**Minto Resource Recovery Facility (SSD-5339)
Response to Submissions**

**Re: SSD-5339 - Proposed Minto Resource Recycling Facility
No. 7 MONTORE ROAD, MINTO**

DRAWING TITLE  
EARTHWORKS SECTIONS  
SHEET 02

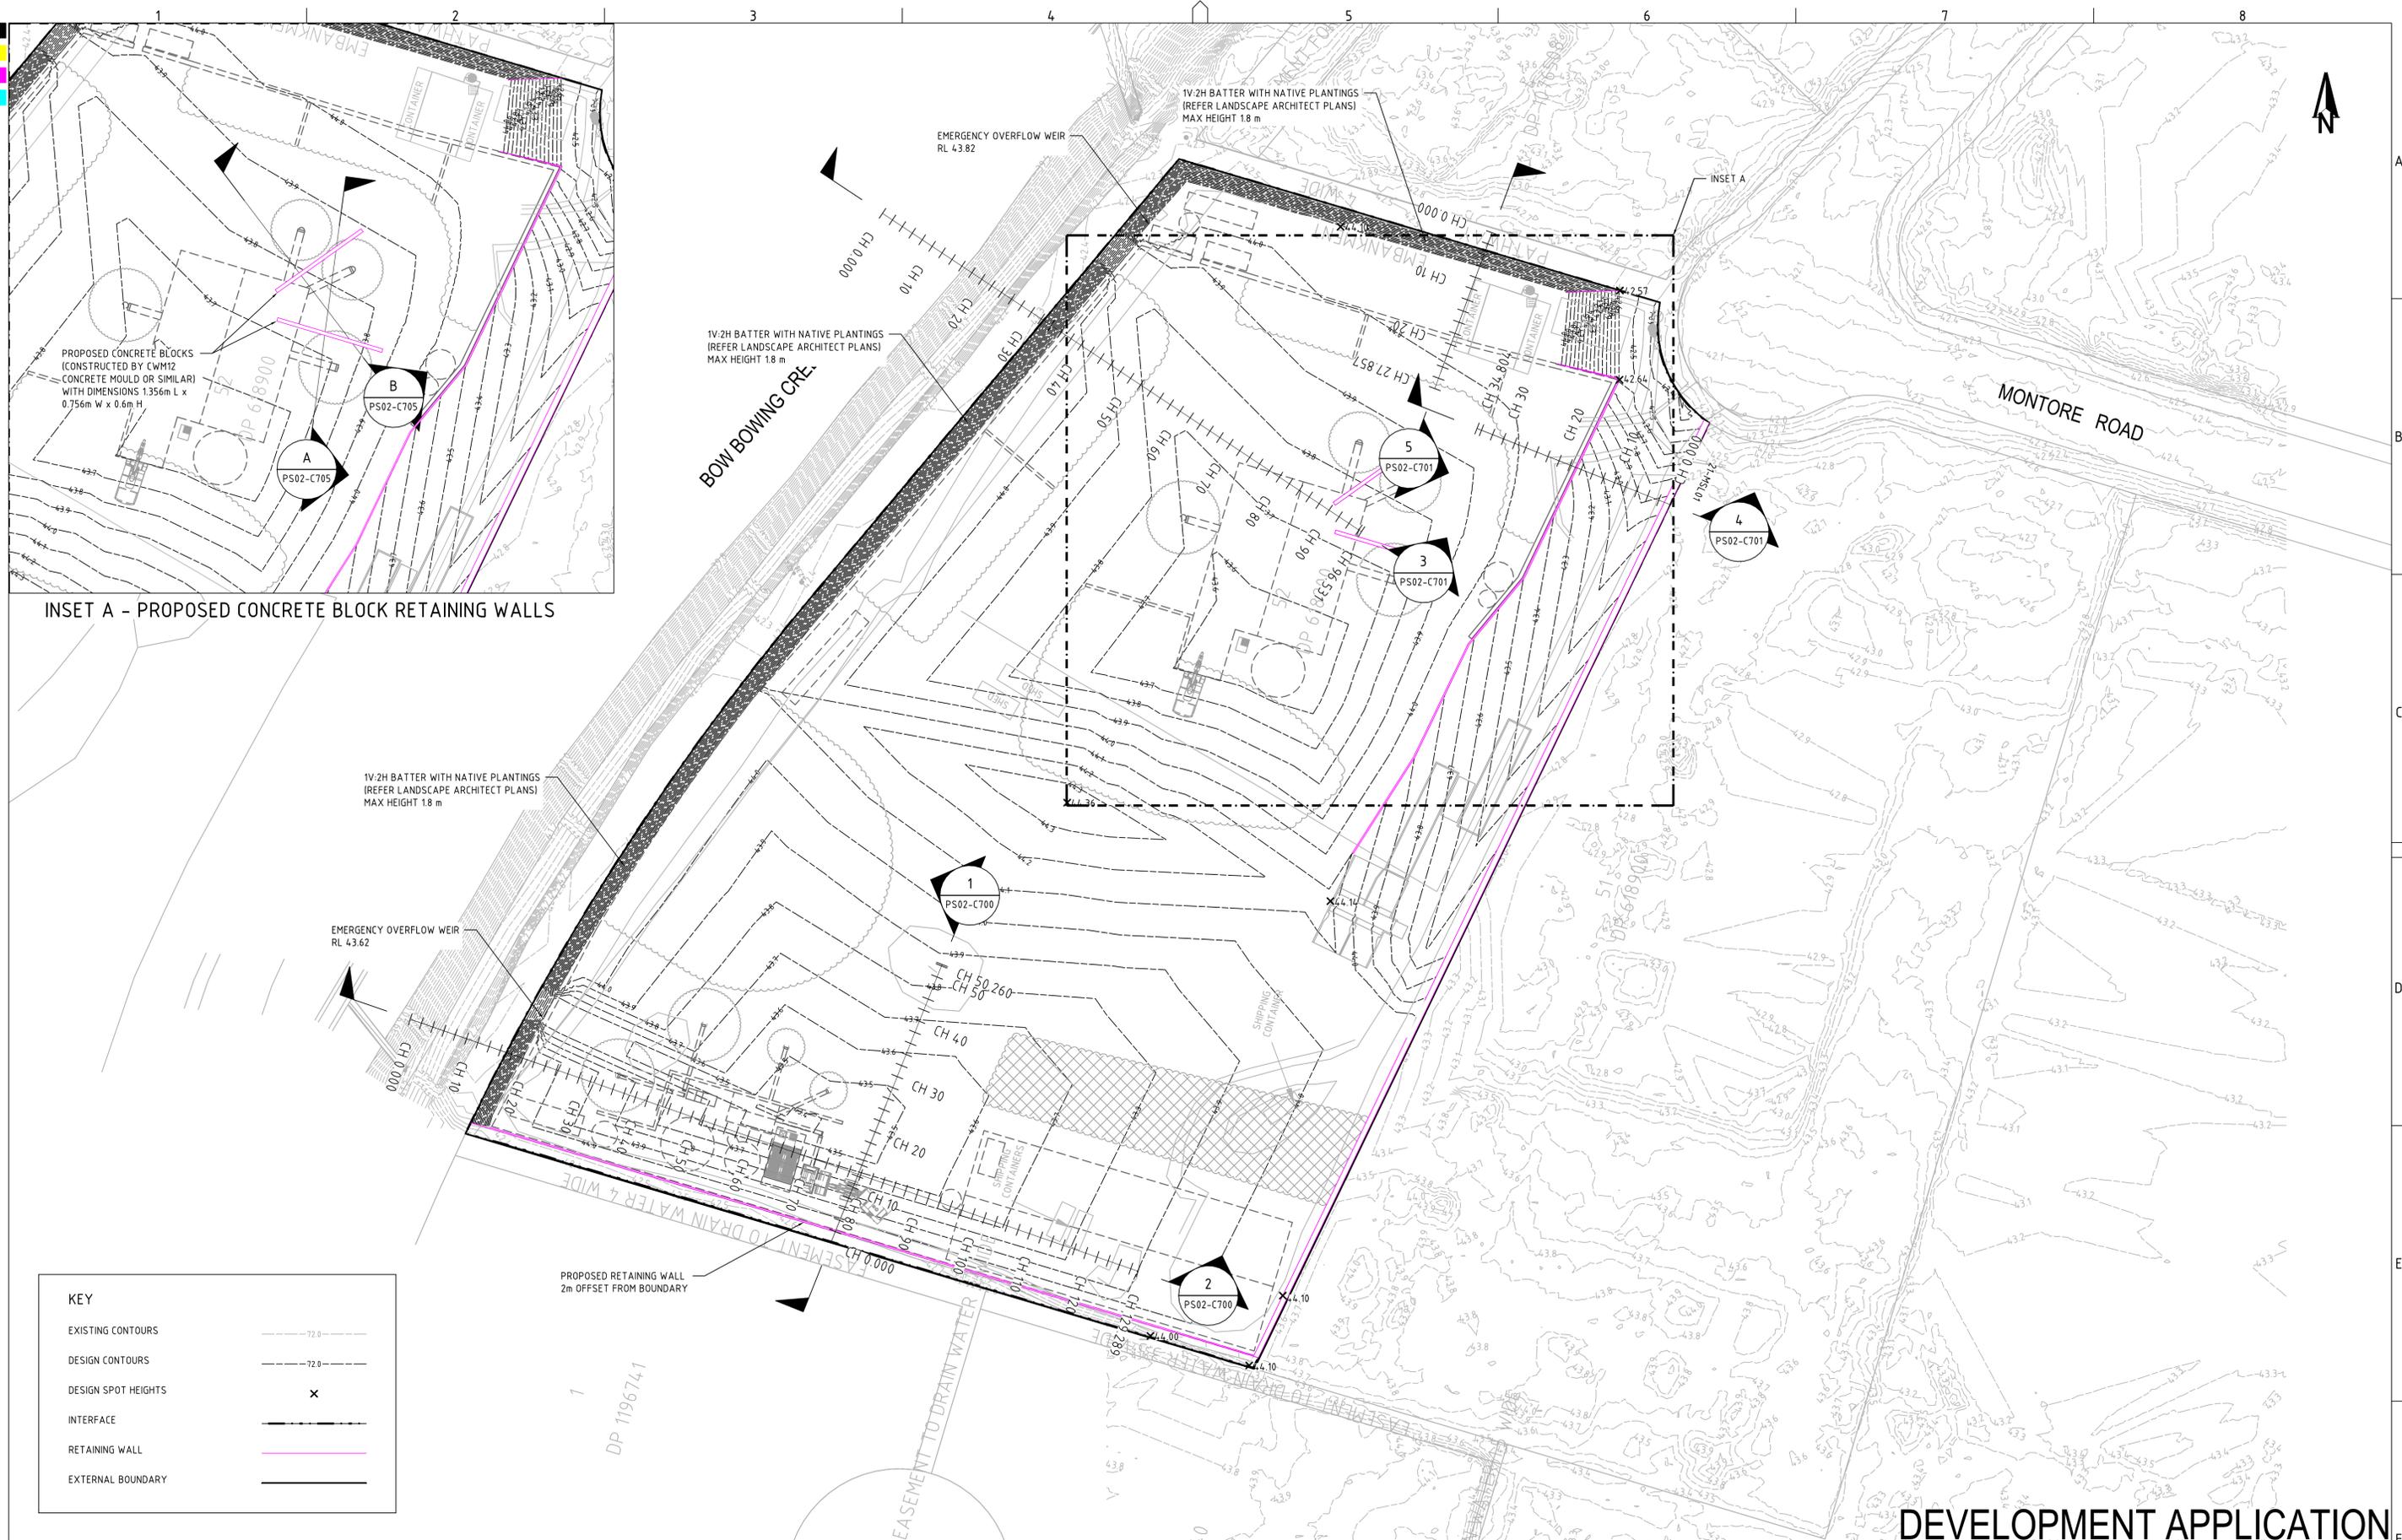
2. The Site Earthworks Plan, completed by Martens & Associates Consulting Engineers, dated 26/06/2020 does not include chainages on the plan sections. This makes interpreting the information presented in the cross and long sections difficult. The changes should be labelled to facilitate more detailed review.

DRAWING TITLE SITE LOADING & UNLOADING PLAN				
PROJECT NO. P1203464	PLANSET NO. PS02	RELEASE NO. R21	DRAWING NO. PS02-DZ10	REVISION F

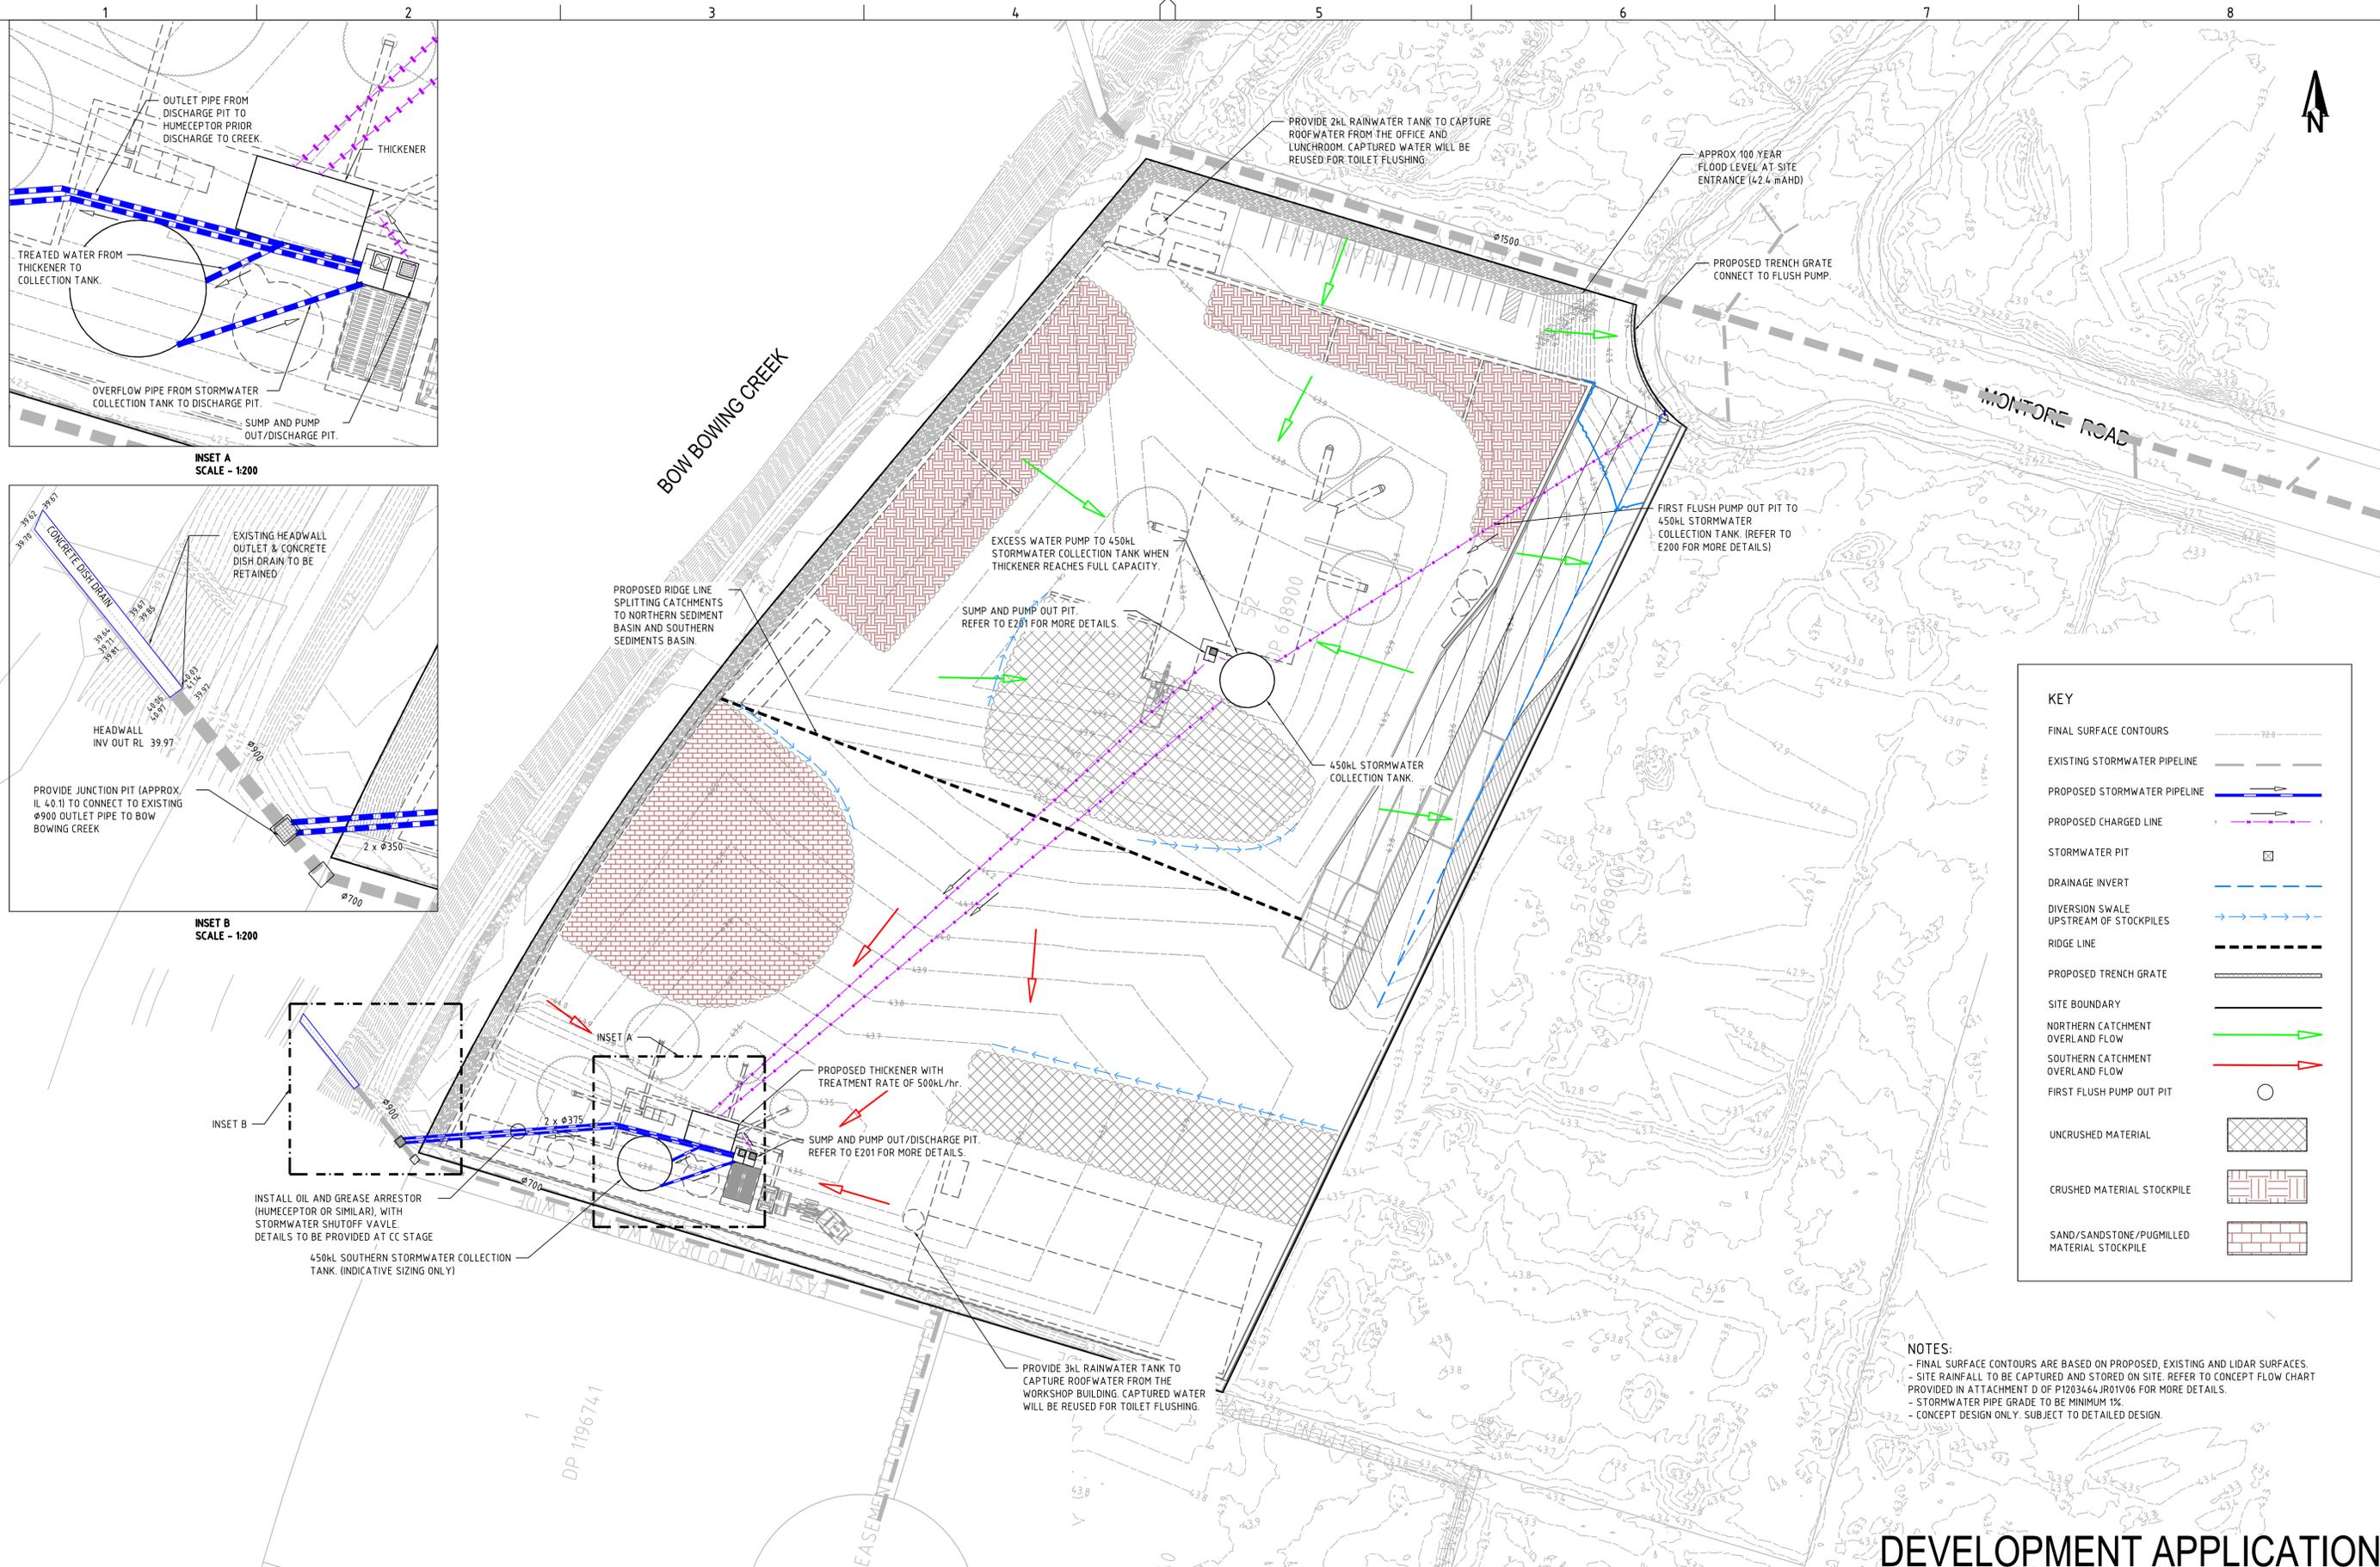
- The swept path for entry manoeuvre for AV into the left most bay indicate vehicle cannot enter safely without encroaching the AV vehicle bay next to it, which implies if vehicles is already in that 2nd bay from left a second AV cannot enter into the 1st/left most bay

DRAWING TITLE				
DRIVEWAY PLAN				
PROJECT NO.	PLANSSET NO.	RELEASE NO.	DRAWING NO.	REVISION
P1203464	PS02	R21	PS02-F101	F

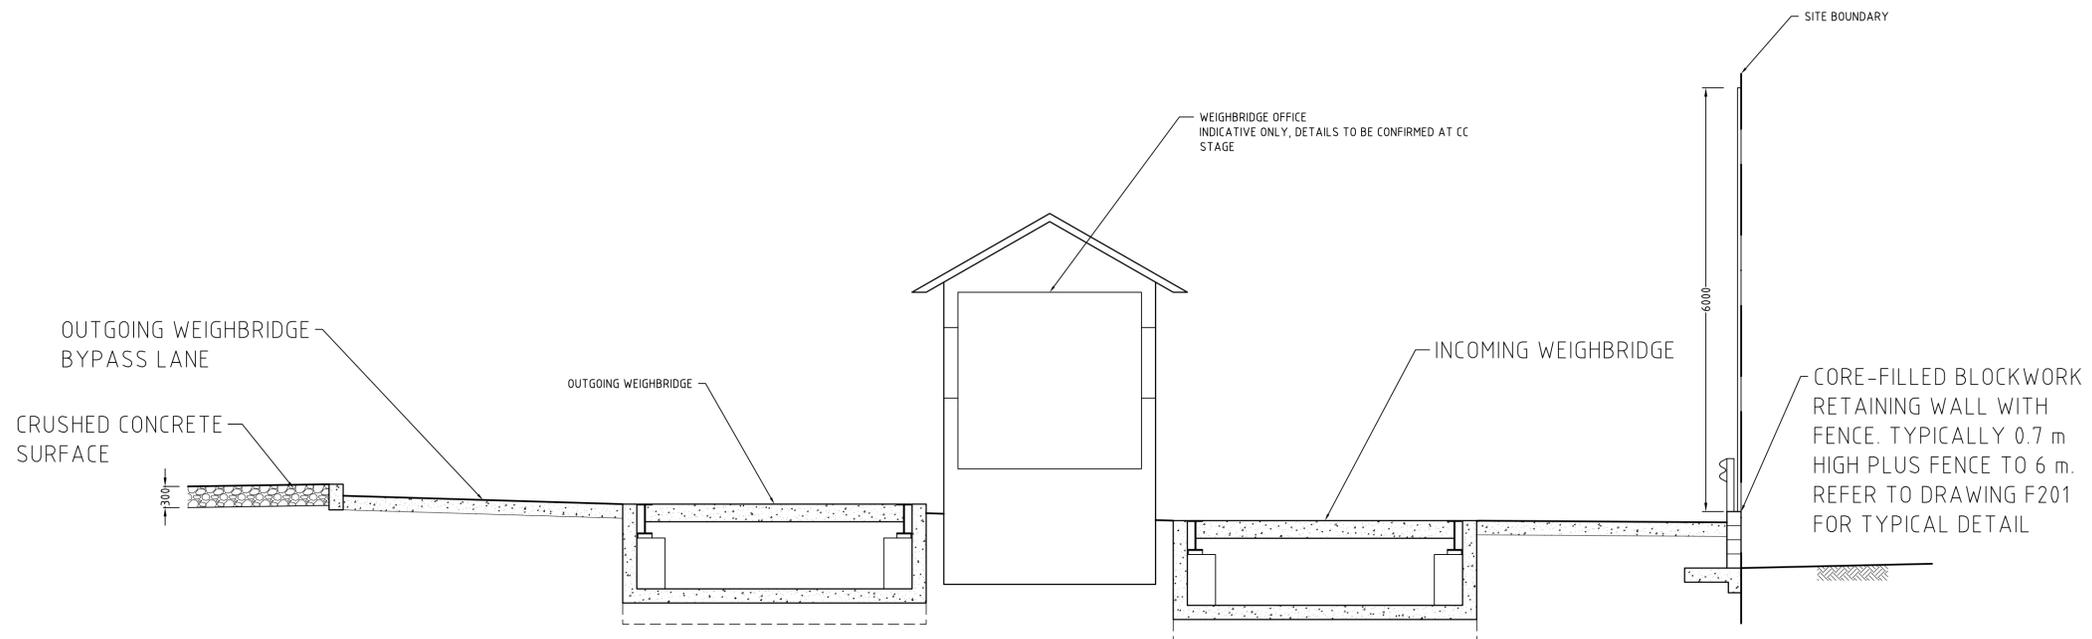
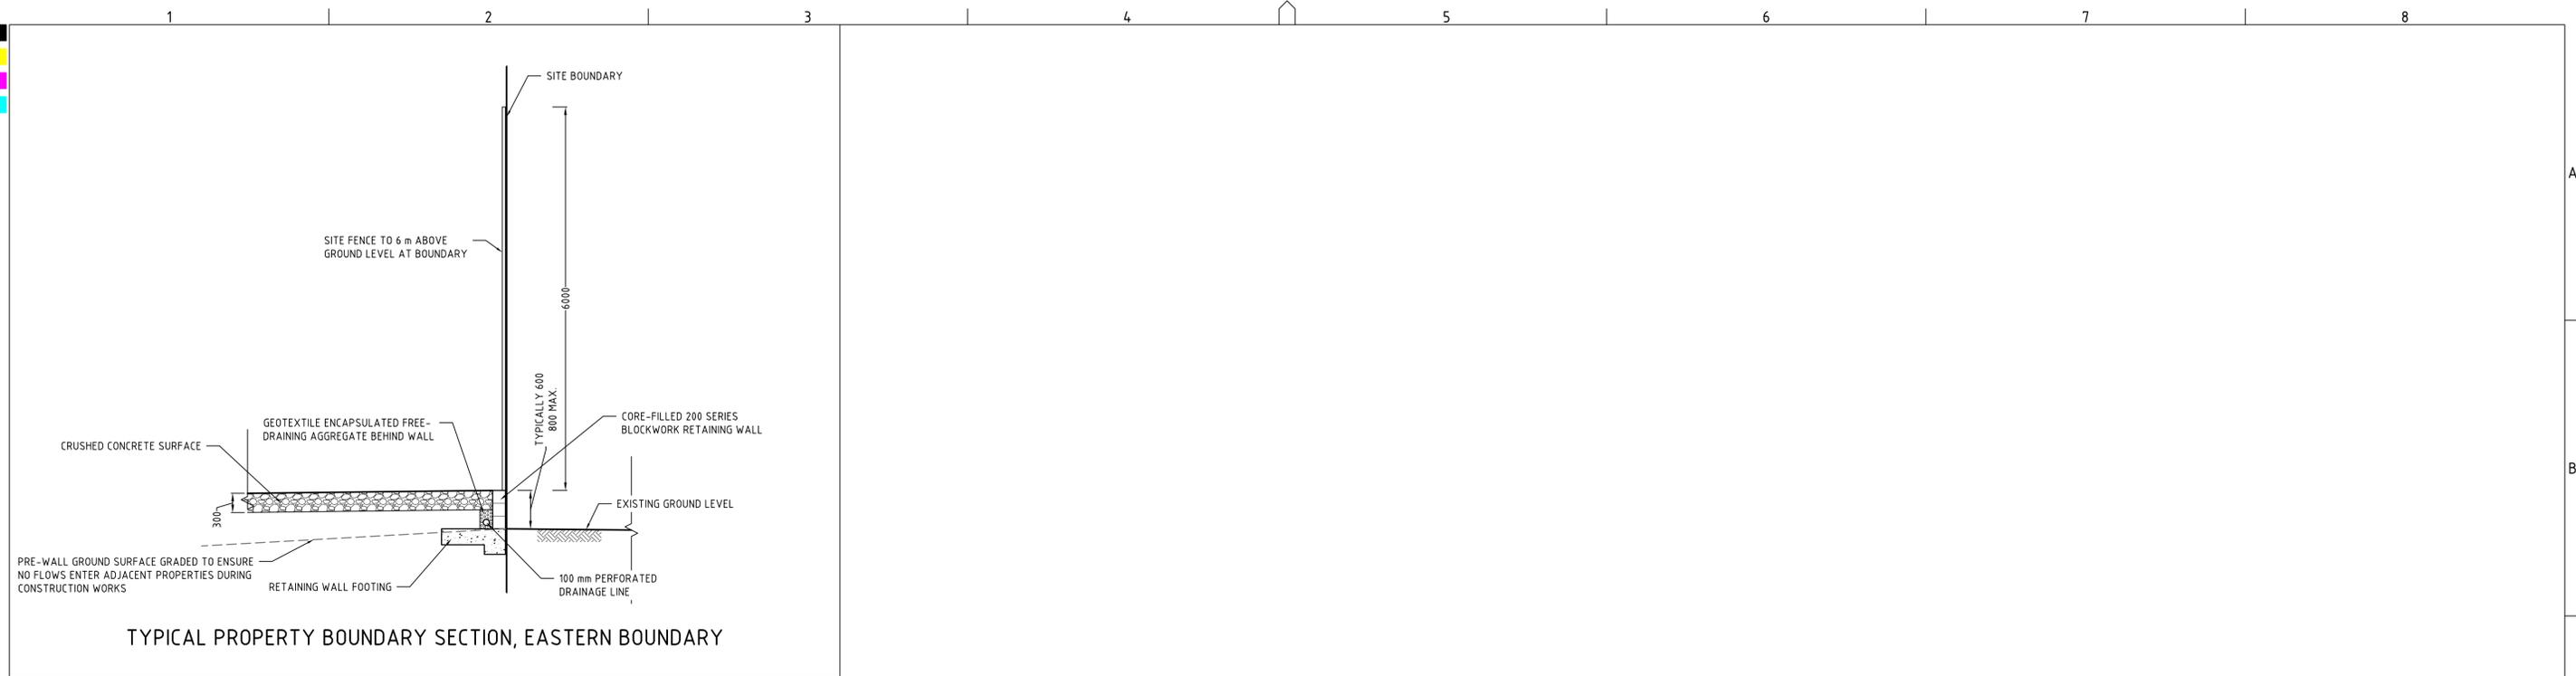
- It is understood that a new driveway/access way would be required to accommodate the development. Please describe the new access and provide the relevant engineering drawings.

- Ensure that the vehicle crossing profile complies with Council's standard drawing SD-R09 Sheets 1 & 2 available on Council's website under Appendix K of the Council's Engineering Guide for Development

- Vehicle crossing shall be designed to provide safe clearance from streets' light pole as per Australian and Endeavour Energy standards
- Council has completed traffic surveys in 2017 and traffic modelling on some of the intersections included in this proposal. Council's modelling identified levels of service significantly lower than those identified in this proposal for the existing conditions. The modelling needs to be addressed by the applicant to better represent the site conditions
